Our ref: OXF7993

Date: 23 November 2020

**RE: OUTLINE PLANNING APPLICATION FOR A NEW FOOD STORE AT COTEFIELD BUSINESS PARK,
BODICOTE (RESUBMISSION OF PLANNING APPLICATION REFERENCE 20/00123/OUT)**

Annex A: Summary of consultee comments and current position (20/00123/OUT)

Project: Cotefield Farm	Job No: 39042
	Drawing Title: Proposed Indicative Signage	Drawing No: 20
1 Water End Barns Water End Eversholt MK17 9EA t 01525 309 400 hello@prosper-design.com prosper-design.com	Client: Will Bratt	Date: Mar 2019
	Drawn: BM	Checked: -
	Scale: 1:50@A3

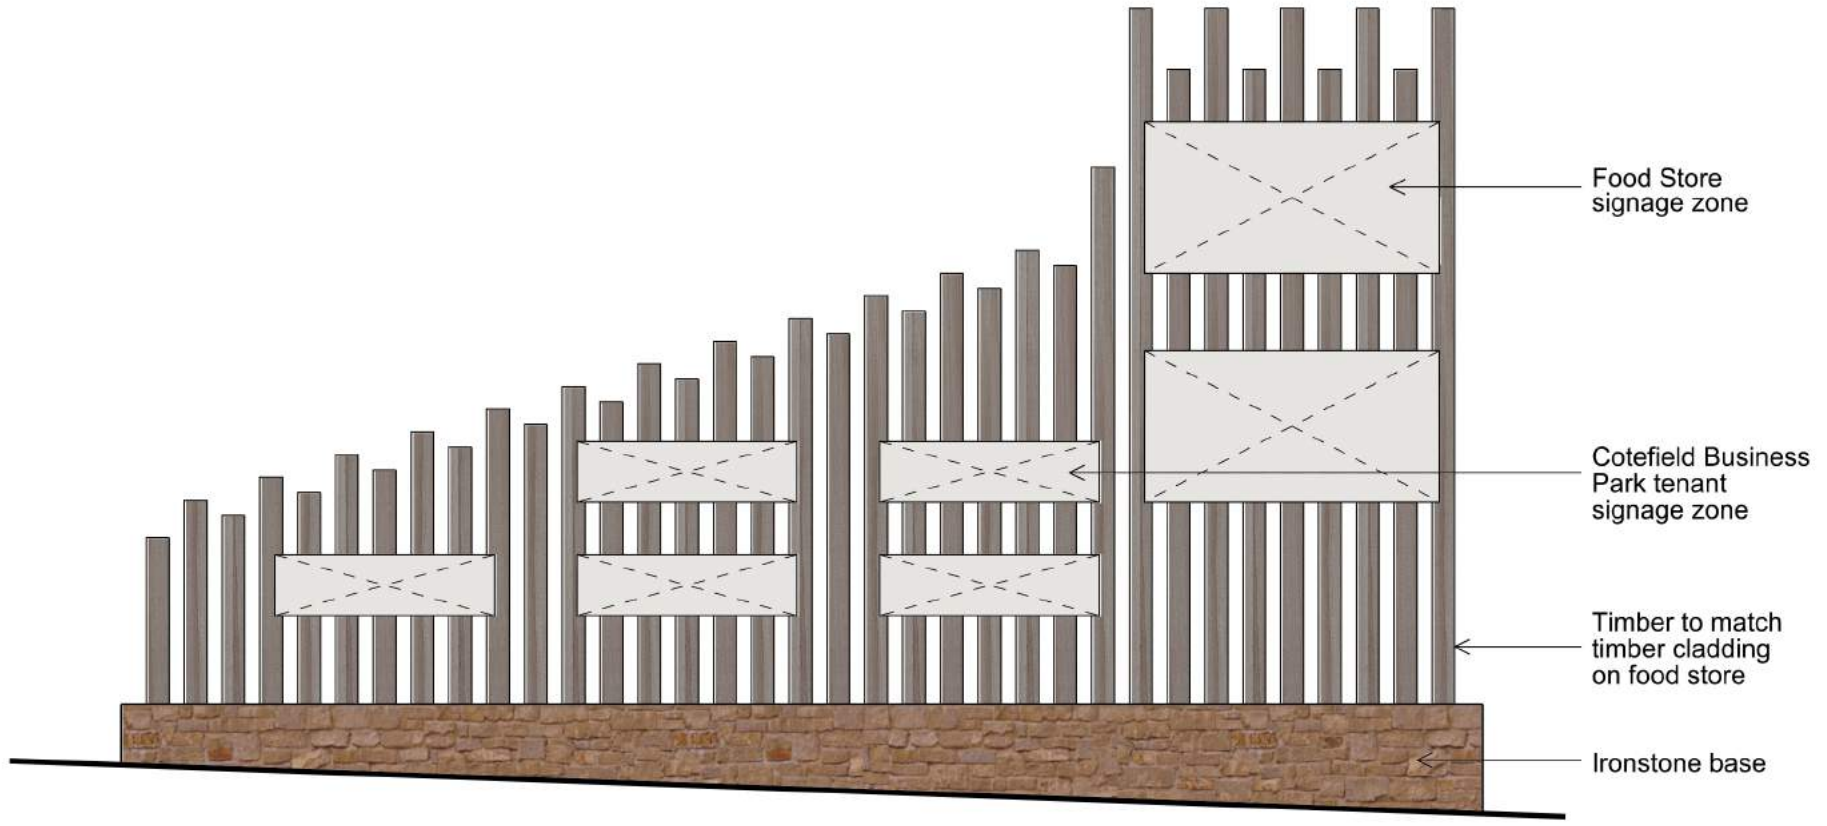
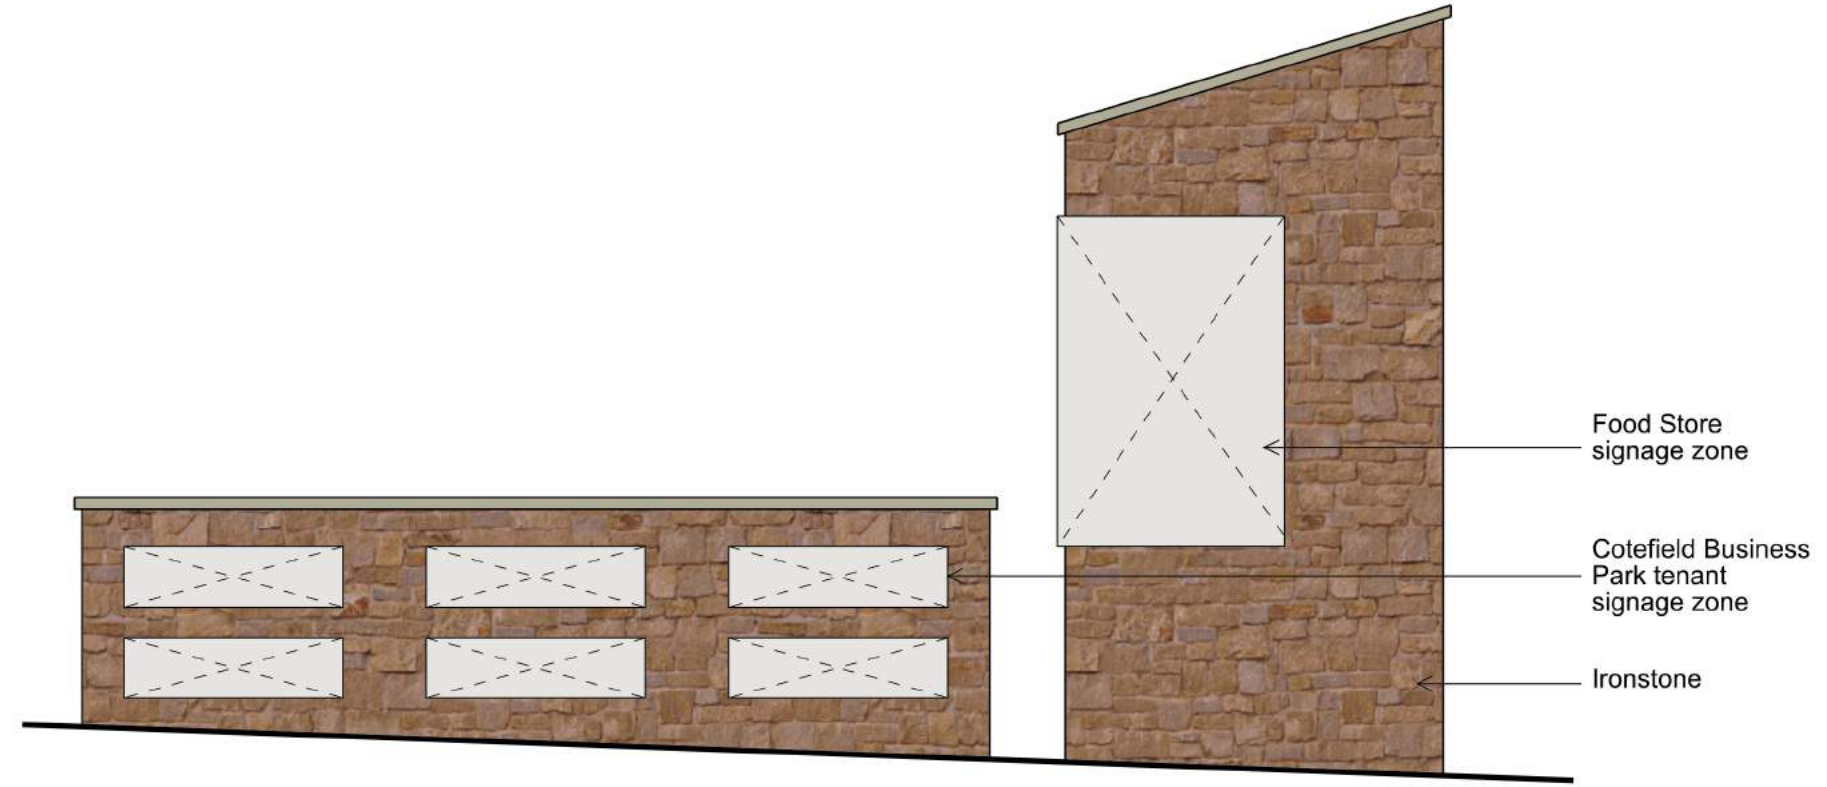
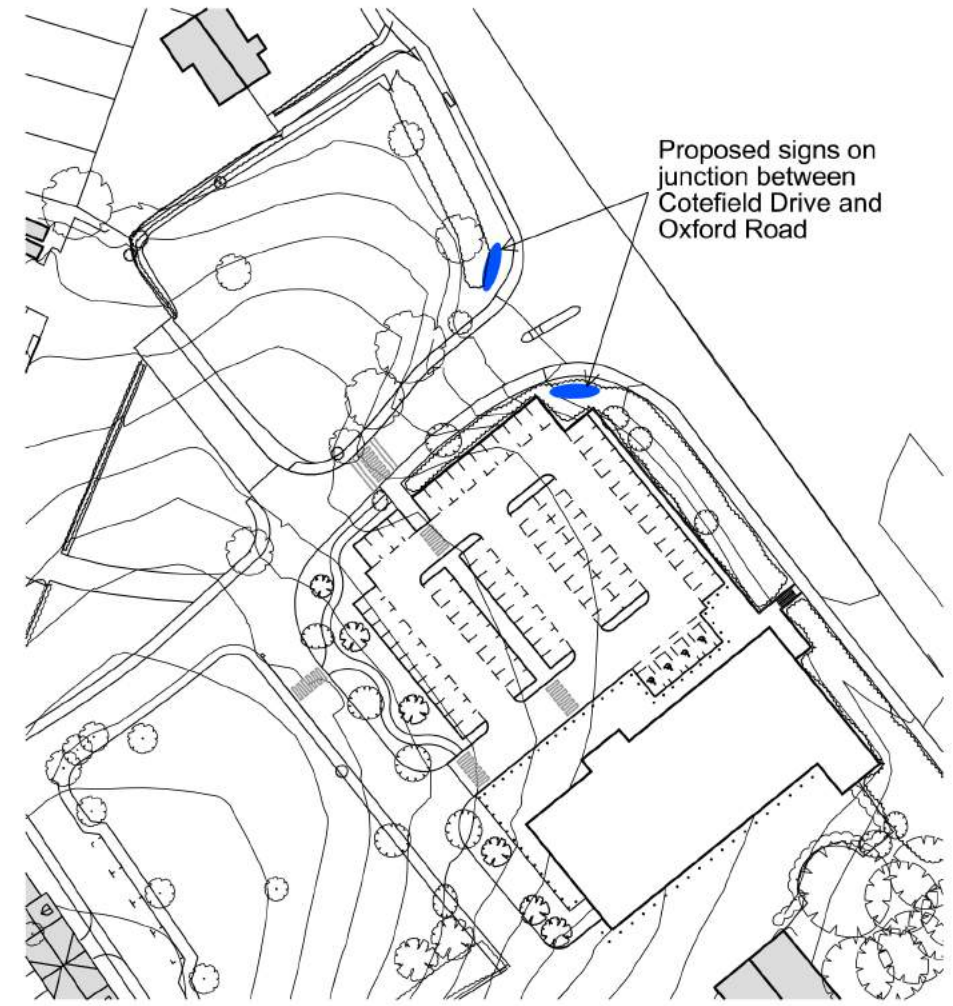
<i>proposed development. I therefore would invite you to respond to the report”.</i>	The Pegasus report is substantiated with up-to-date evidence and shows that the likely impact of the proposed development would not be significantly adverse and is in accordance with relevant planning policy. Further, the Pegasus report arrives at this conclusion without considering the likely future population growth in the immediate area – adding this in would suggest a potential significant shortfall in adequate convenience shopping provision in the area which the council should be looking to address.
Other Officer comments	N/A	Signage on the site frontage/near the A4260: <i>“Whilst the signage is only indicative at this stage it is unlikely that we support signage on both sides of the access off the Oxford Road”.</i>	The applicant notes and welcomes this feedback. We would like to discuss this matter further with the case officer before removing the signage from the proposals.

SURFACE WATER
DRAINAGE STRATEGY

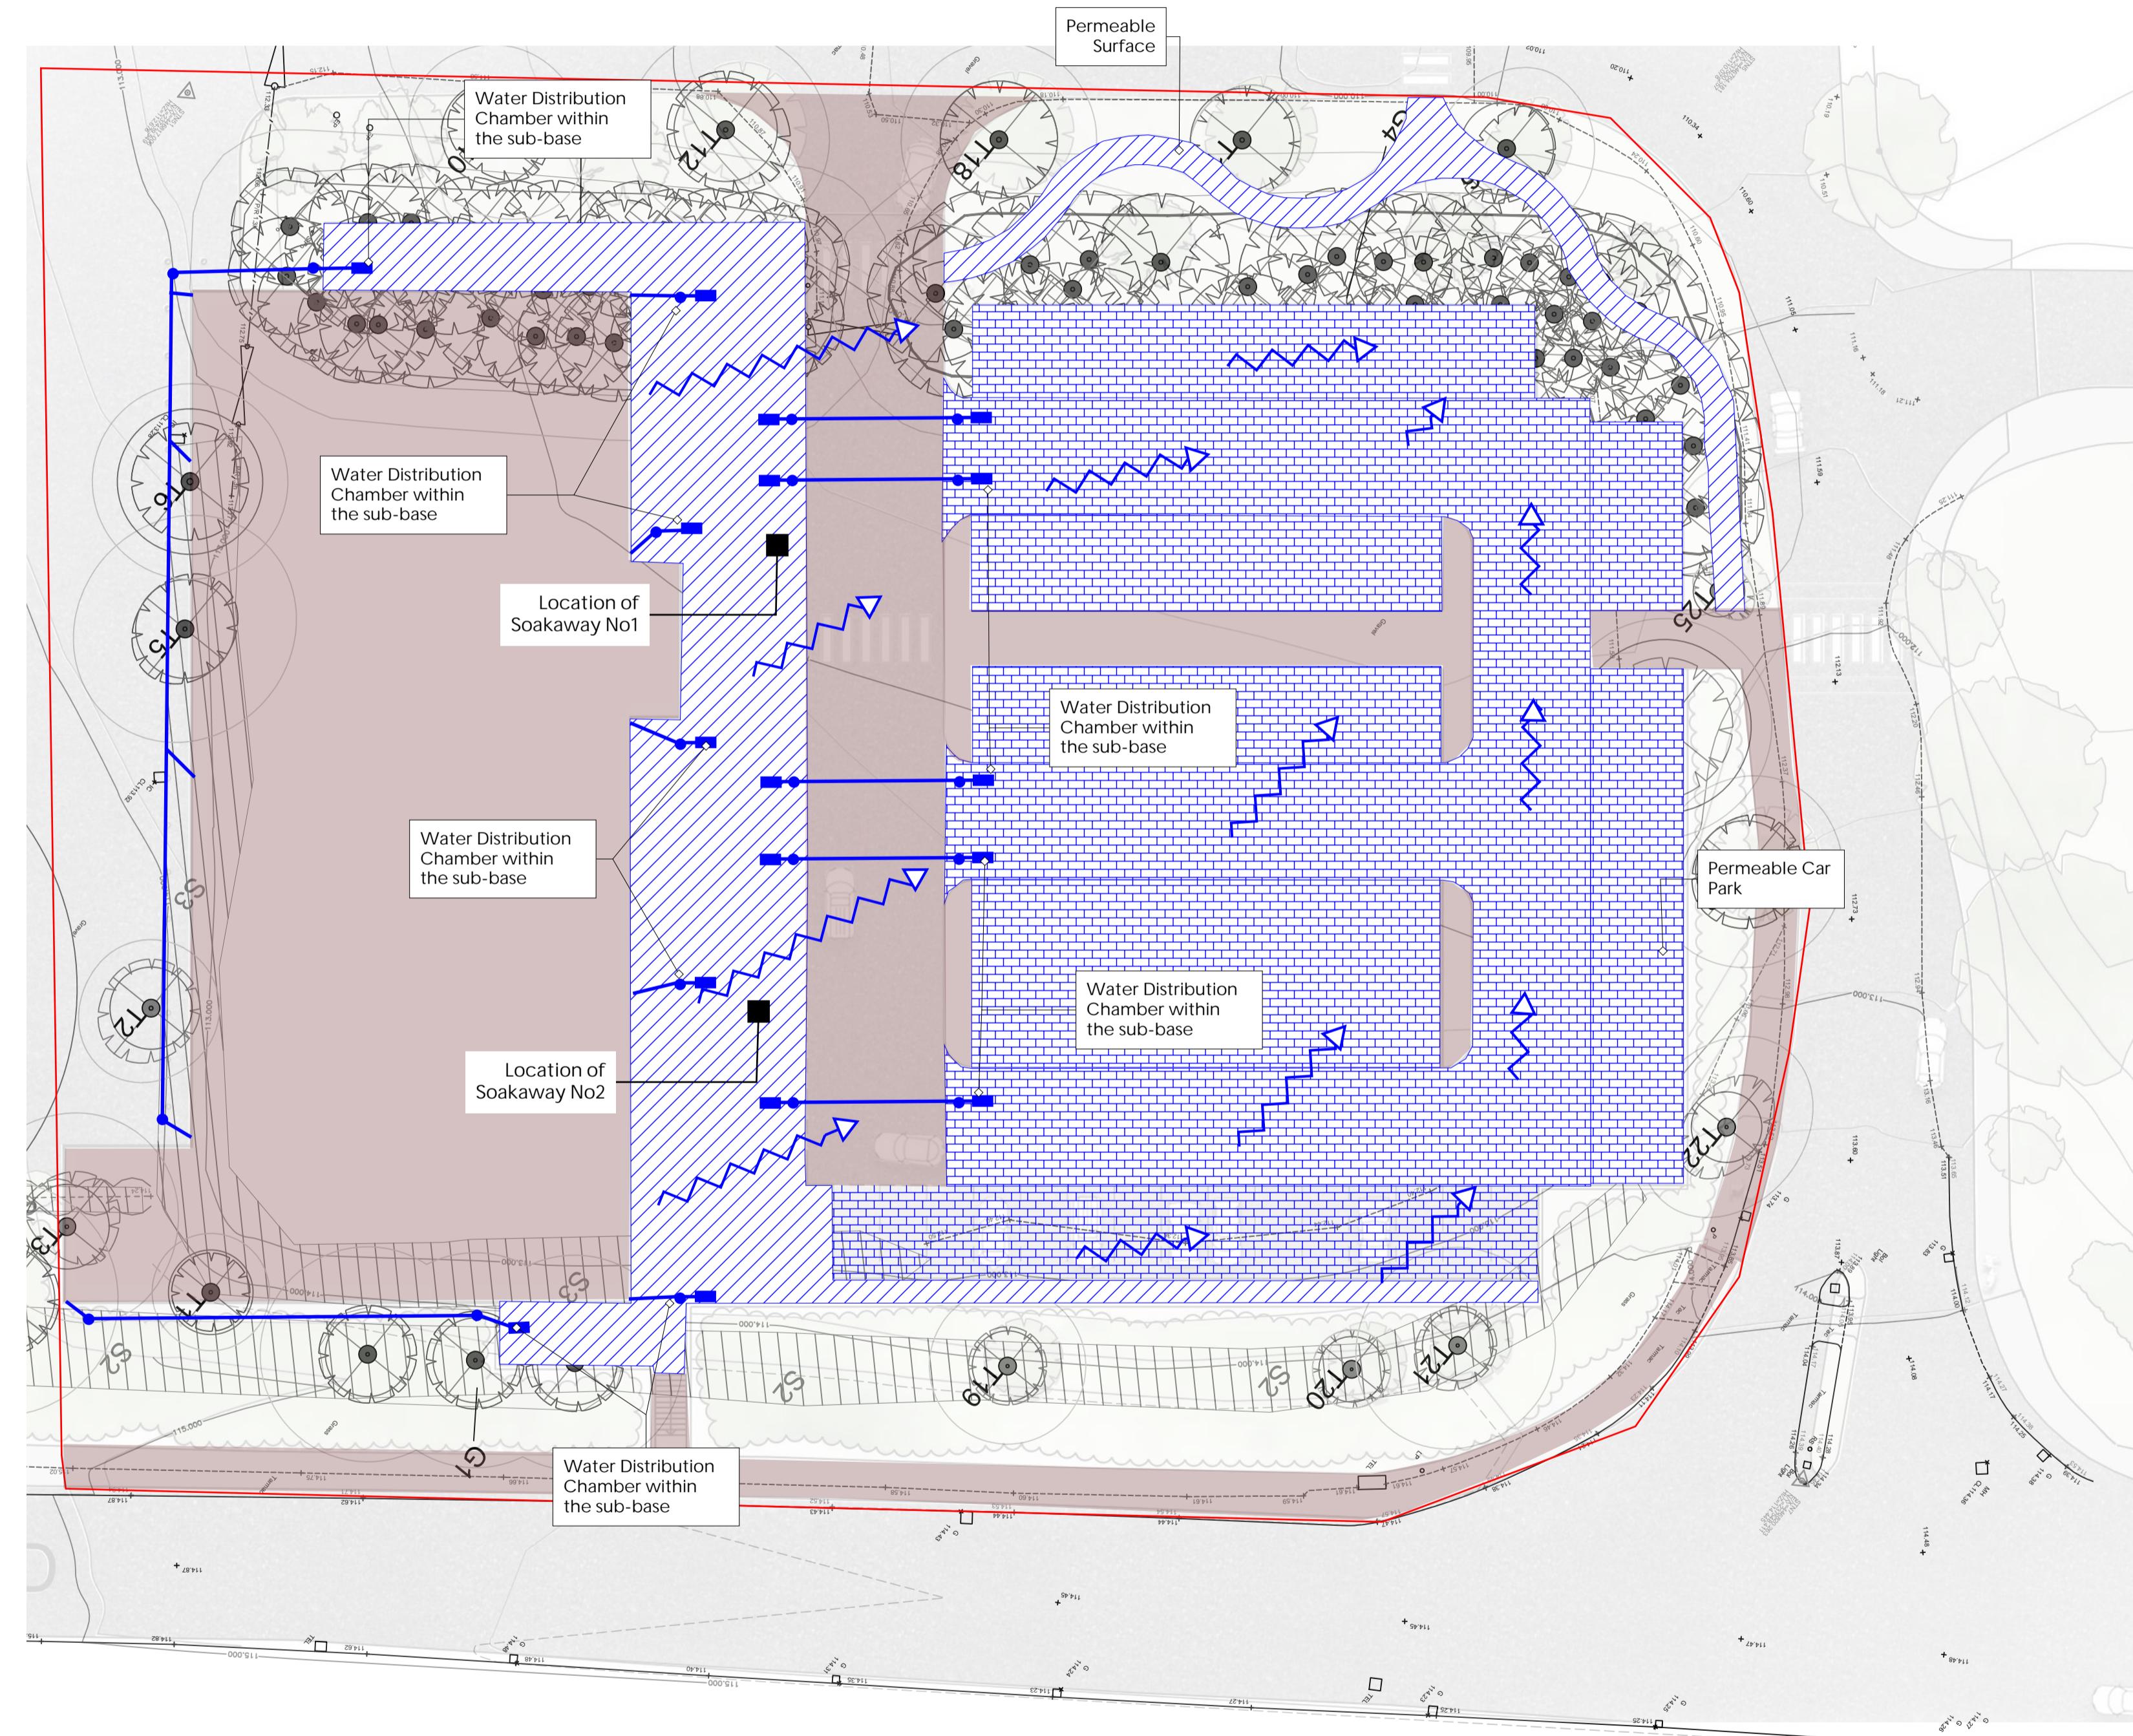
Oxfordshire County Council (OCC) – Lead Local Flood Authority (LLFA)	17/02/2019	<p>Further information required to enable full technical assessment of flood risk, drainage strategy and SuDS usage for the proposal.</p> <p>The proposed infiltration system cannot be validated without the following information:</p> <ul style="list-style-type: none"> • Ground water test results required • Borehole data required • BRE365 Infiltration test and shallow infiltration testing results required. • Full calculation files with associated drawing detailing these pipe numbers required. 	<p>A revised drainage strategy report has been prepared and is submitted with the application (document reference CFD-SOLID-XX-XX-RP-C-001). This is provided to provide greater definition of the drainage proposals at this stage, in response to the comments of the LLFA.</p> <p>The revised report includes details of infiltration testing that has now been carried out, along with microdrainage calculation files. We will engage further with the LLFA on the drainage strategy once the application has been registered and the revised report sent to them for review.</p>
